July 17, 2007

Re: 70 Olympia Street – 433 B017 – R-5 – deck

BASIC PROPERTY OUTLINE

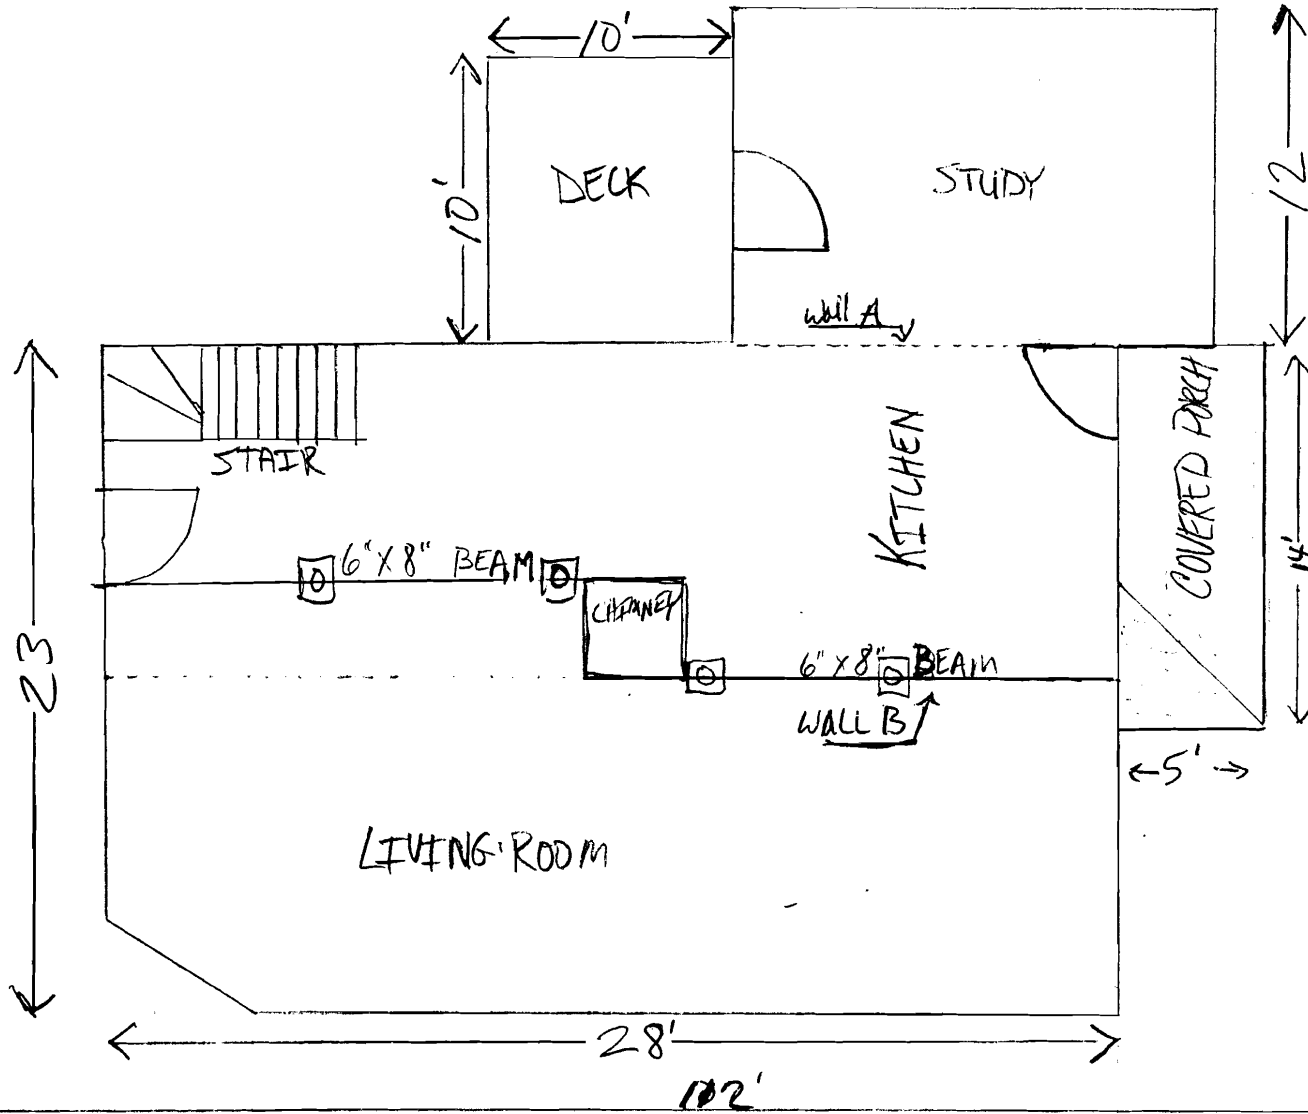
In reviewing your application (permit #07-0810) to remodel your kitchen and rebuild the existing covered porch at your property at 70 Olympia Street, I had to research the permit history of the property since it is located in the Shoreland Zone. During this process, it came to my attention that the ten by ten foot deck shown on the plot plan was never permitted. Since it was not permitted, you have no legal right to it. You must either apply to permit the deck after the fact or remove it.

If you decide to permit the deck after the fact, you will need to provide a site plan drawn to scale by a licensed professional that shows the lot and the structures on it and the seventy five foot setback line from the highest spring tide since your property is located in the Shoreland Zone.
